Case Officer: Shona King

Recommendation: Approve

Proposal: Discharge of Conditions 5 (drainage details) & 9 (driveways, accesses and turning areas) of 21/02318/F

Client	rectory
Project	South Side Steeple Aston
Scale:	1:200 @ A1
Status:	PRELIMINARY
Drawn:	Project Engineer
Checked:	RF
Project No:	6374
Date:	14/05/2021
Drawing Number:	6374-MJA-SW-XX-DR-C-200
Rev:	P4

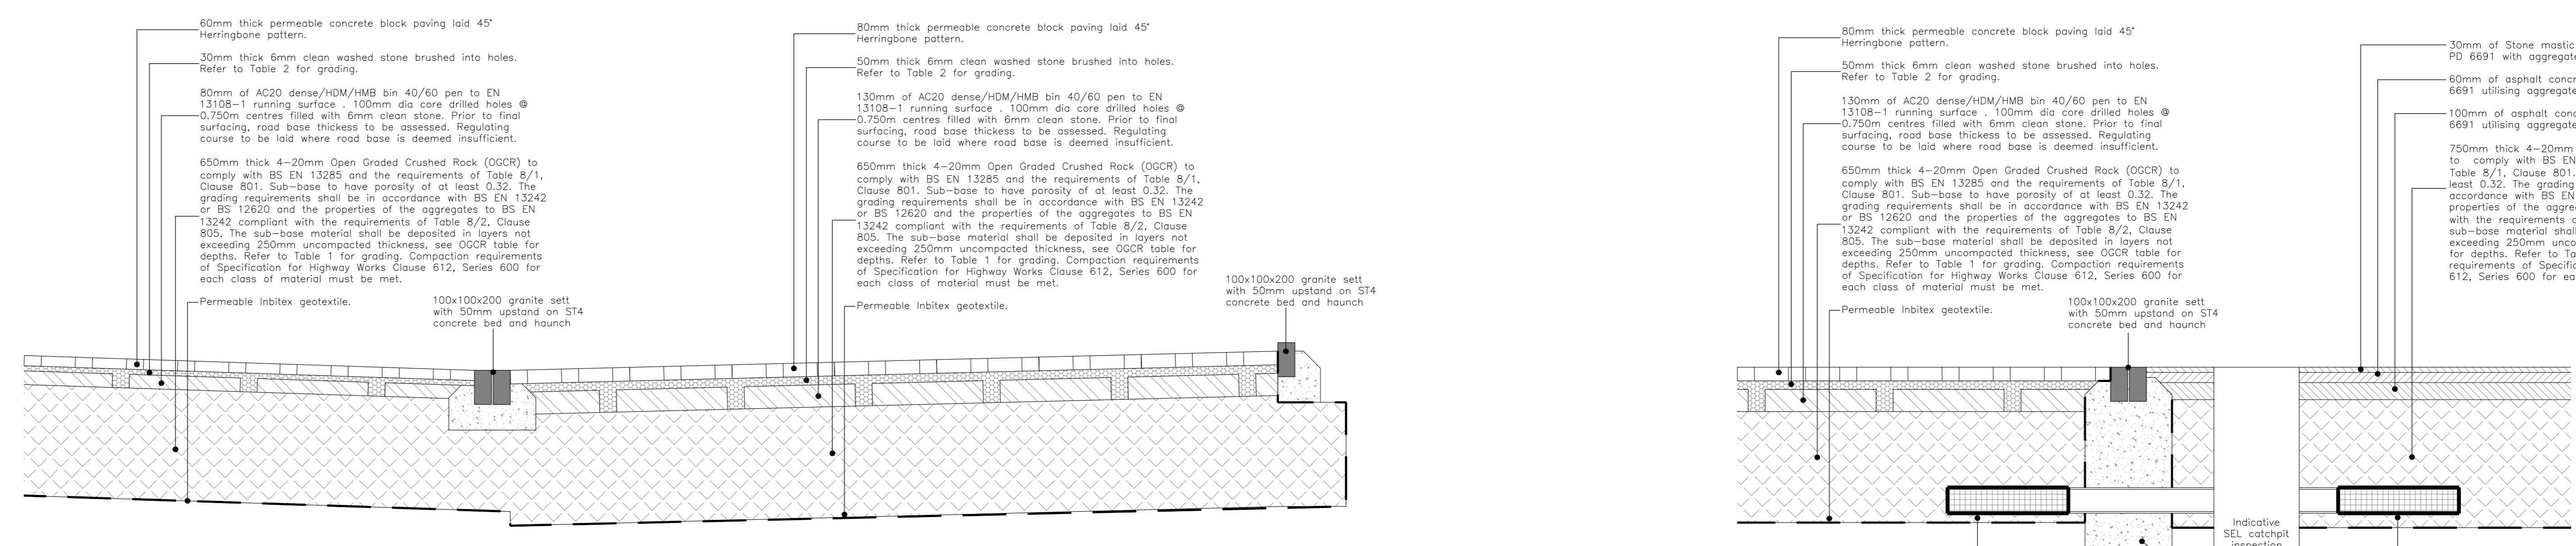
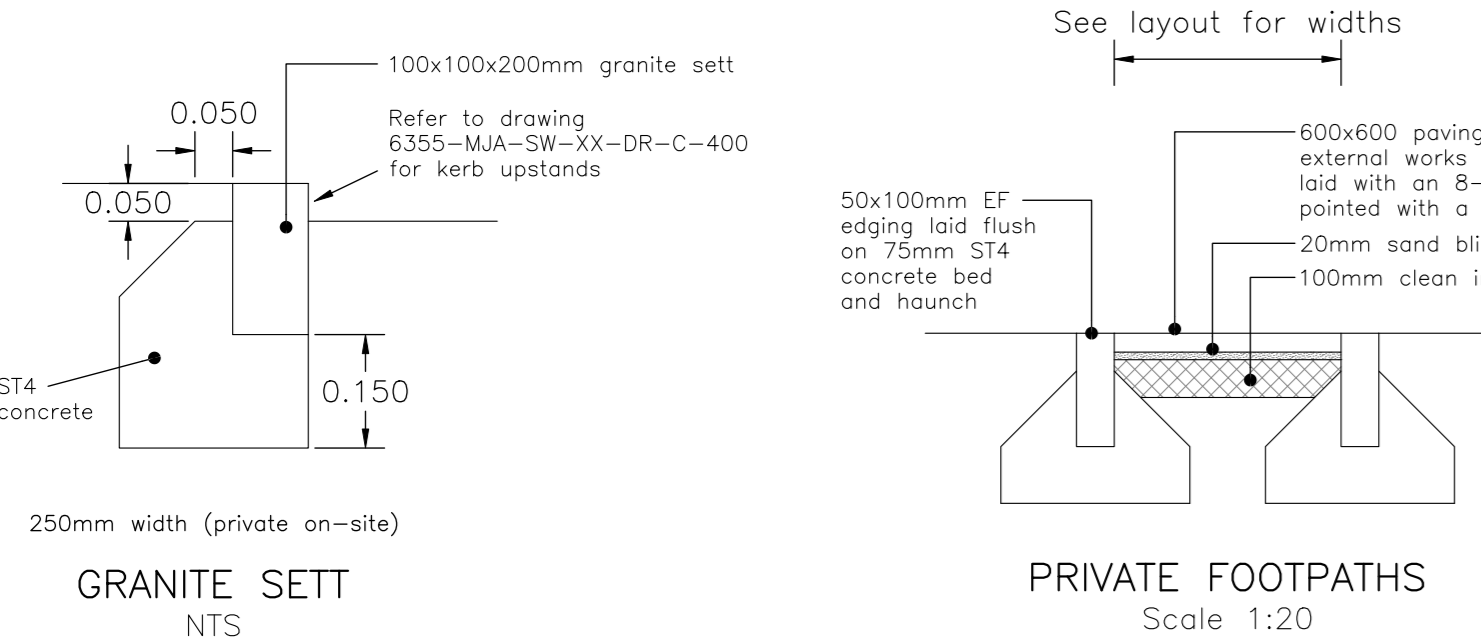
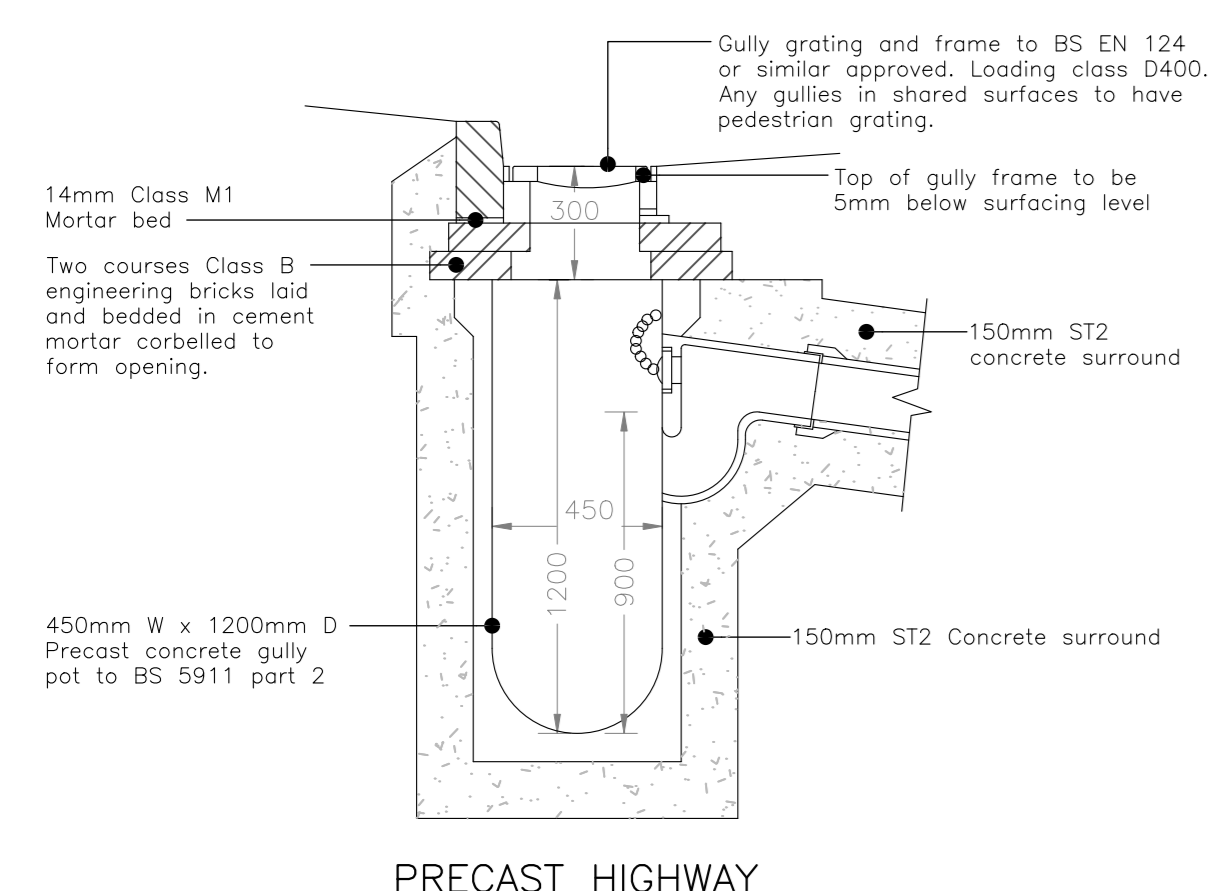
- There are no sub base references added to the drainage plan. In order to review and understand the calculations, provide the reference of the sub base on plan.
- Provide the storage area and sub base thickness on the drainage plan in order to review the calculations and ensure the design is consistent.
- 100mm drainage pipes are used around the plots to take the roof areas, evidence needs to be provided that the drainage pipes can take the proposed roof areas without flooding.
- Provide flood exceedance plan with the proposed levels overlaid, to demonstrate that all surface water will be kept away from structures and within the site boundary.
- Provide a maintenance regime for the proposed SuDS, identifying all the maintenance requirements.
- Clarification required on how surface water quality will be managed during construction.

5.3. OCC LEAD LOCAL FLOOD AUTHORITY: Response on additional information 28-06-22 – No objection
